FORMAL COMMUNITY SUBMISSION OF OBJECTION

Application Ref: Mixed Use Development (with In-fill Affordable Housing) – 138 Maroubra Road (SSD-81426710)

Impacted Stakeholders: Adjoining Residents and Senior Citizens of the Maroubra Pacific Square Precinct

1 2 PM - JUNE 21st
1 : 500

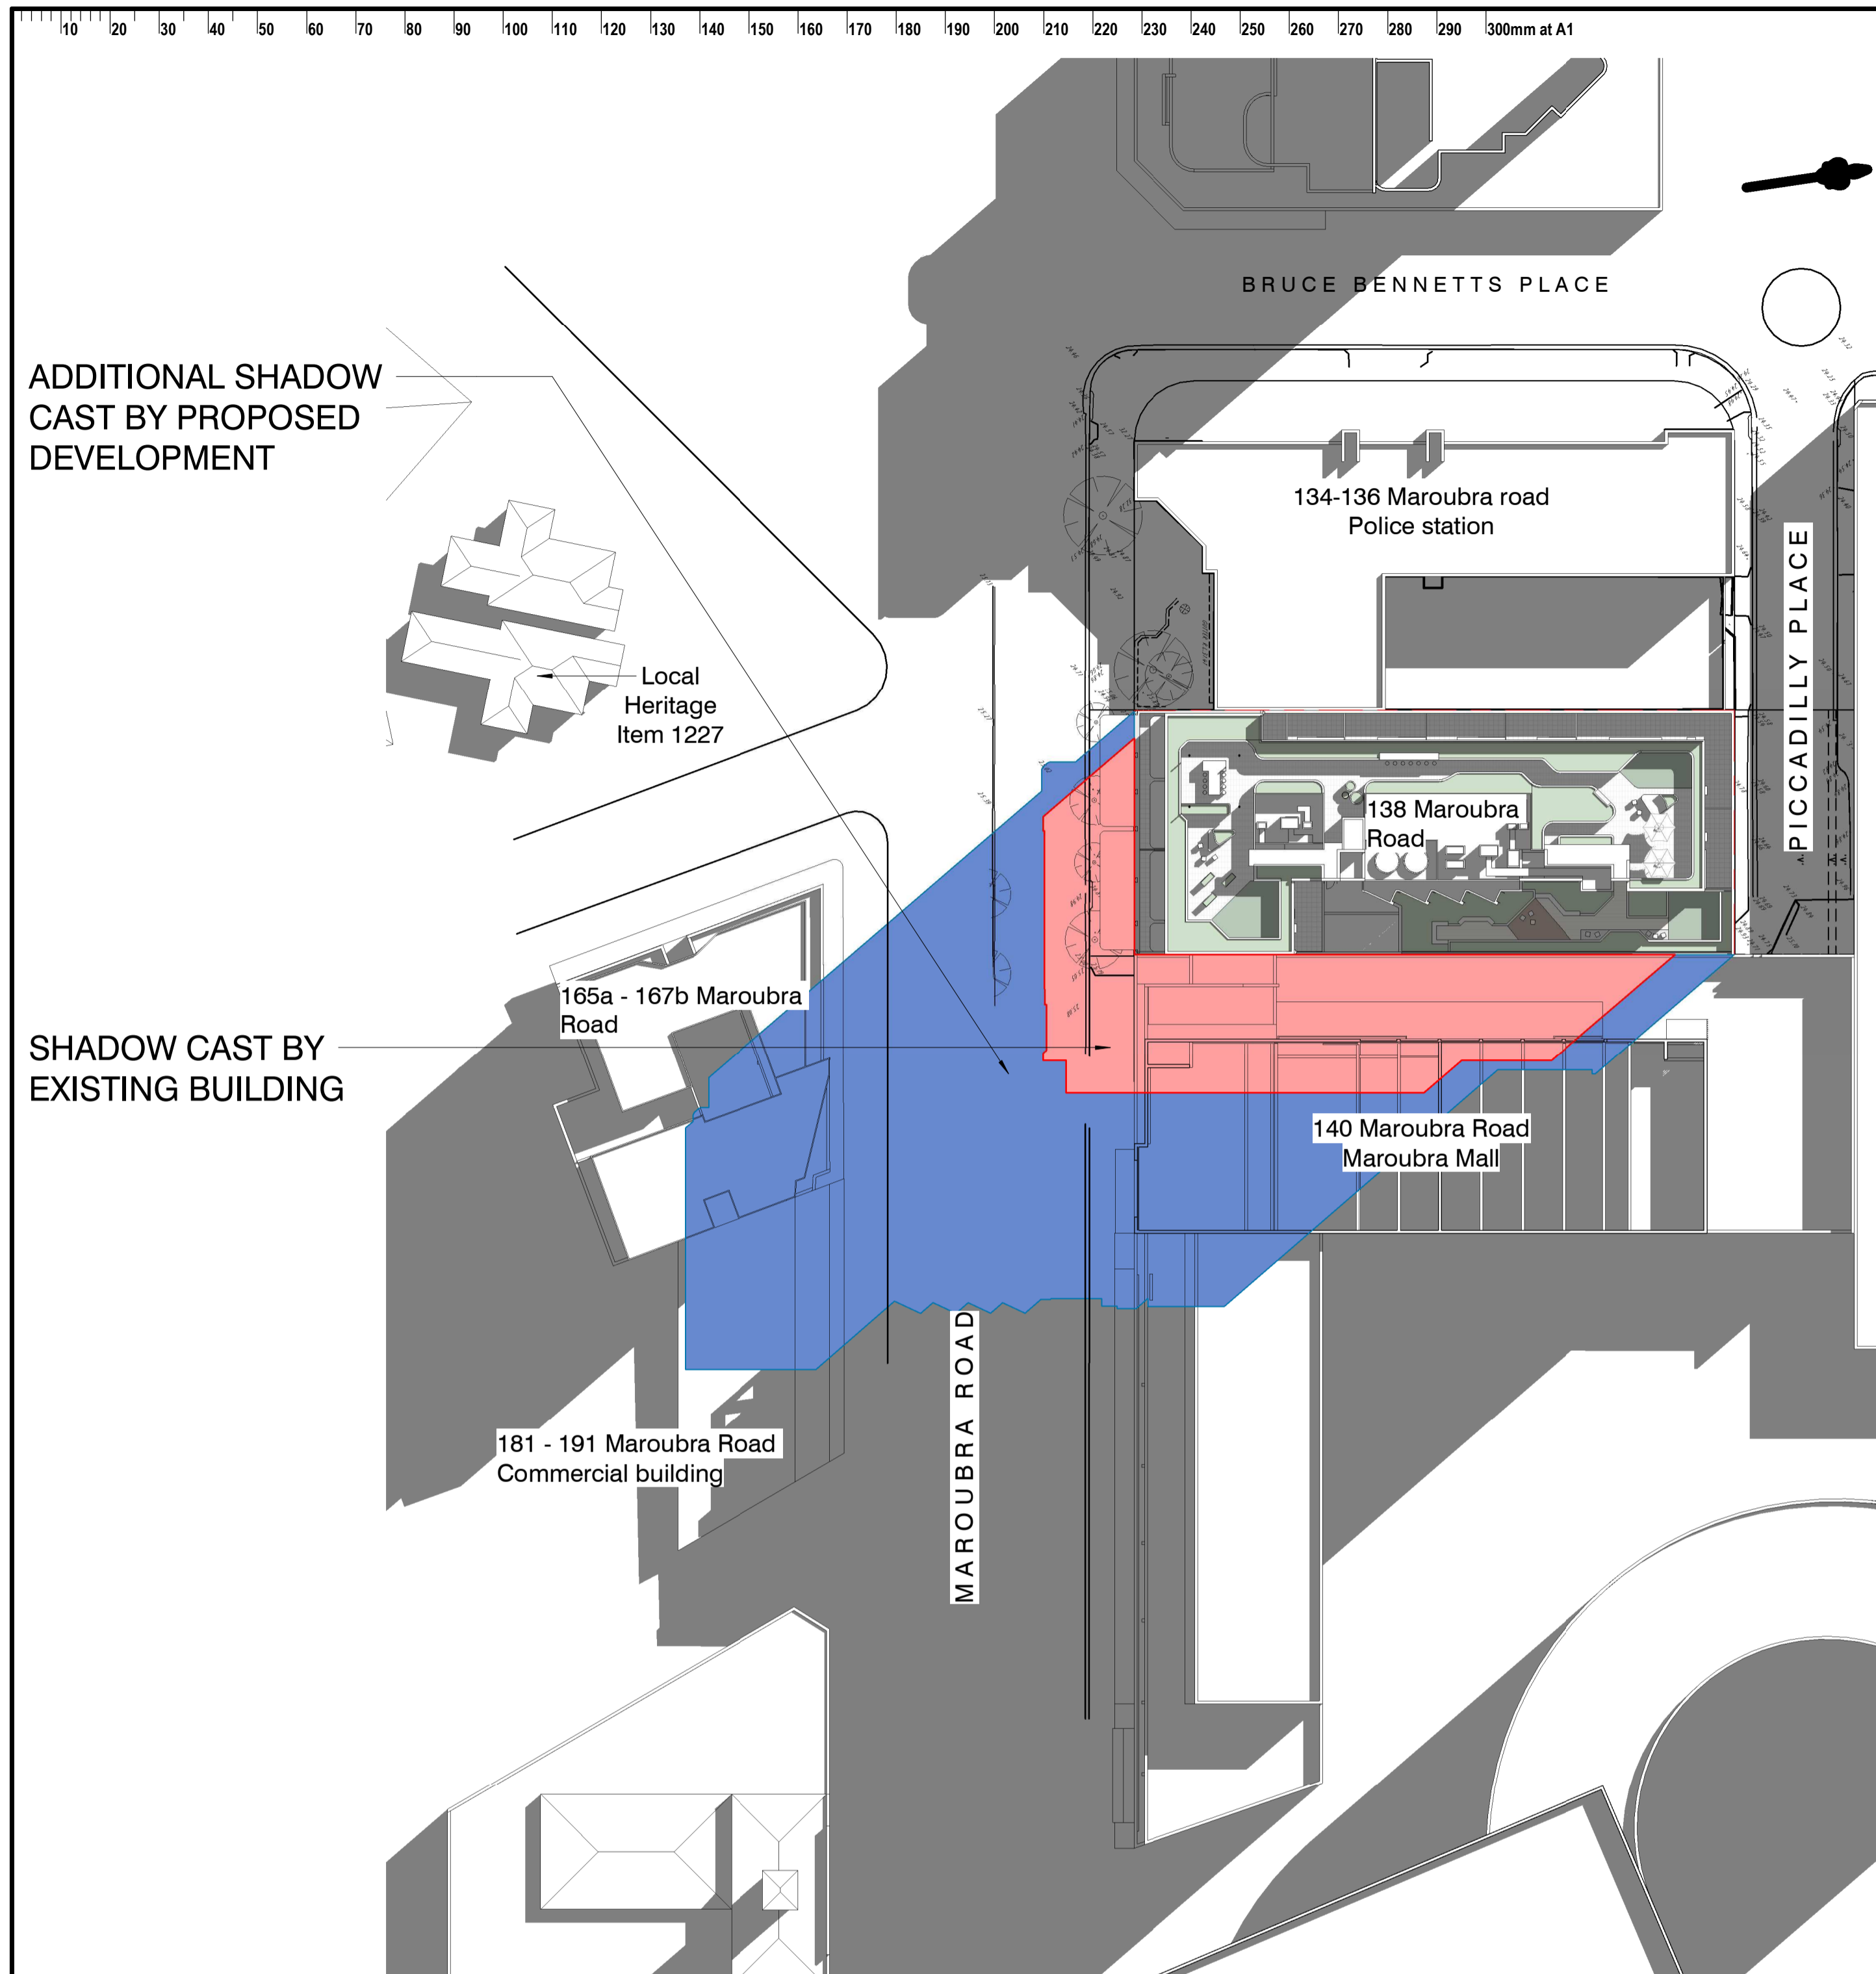
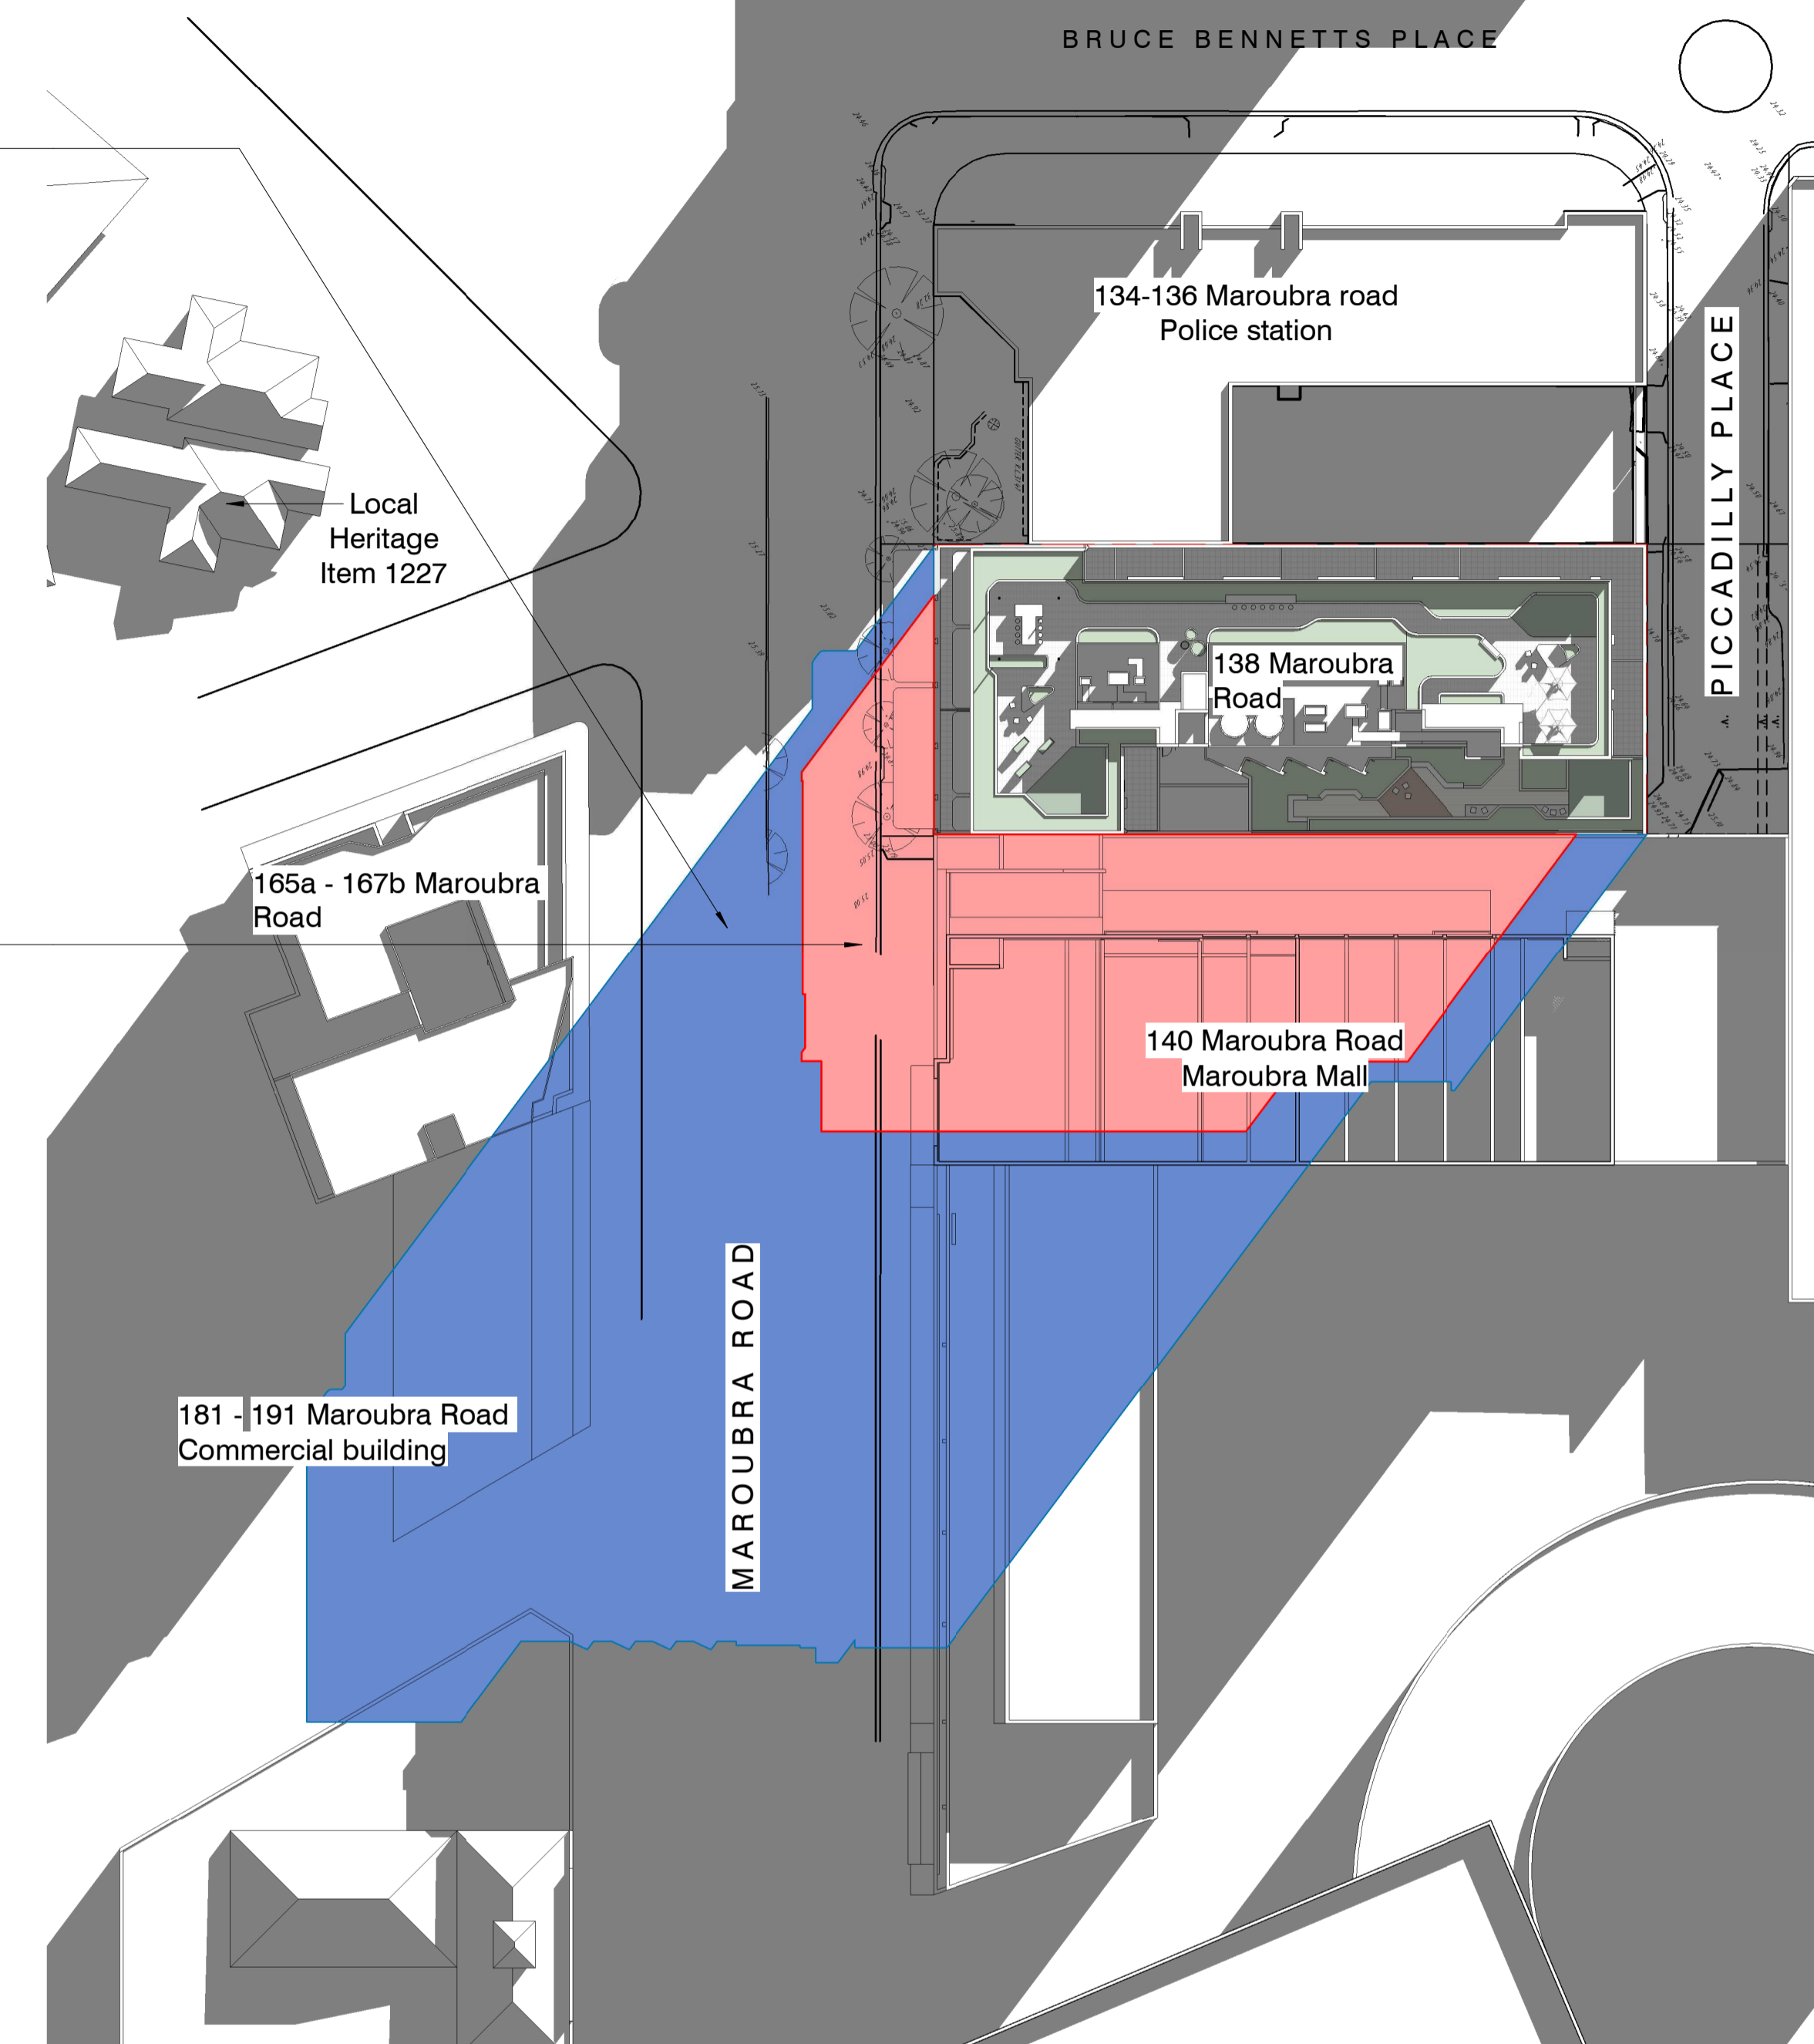
The submitted shadow modeling relies on generic, regional guidelines under the Apartment Design Guide (ADG), completely ignoring the specific microclimatic reality of the surrounding residences. Building a deep, vertical 10-storey structure directly to the west completely cuts off crucial afternoon daylight.

Natural sunlight is an essential requirement for the health, well-being, and internal apartment heating of elderly residents, many of whom suffer from limited mobility and remain indoors. Depriving these living spaces of essential afternoon light hours early creates cold, dark internal environments that directly degrade the daily health and comfort of our senior community.
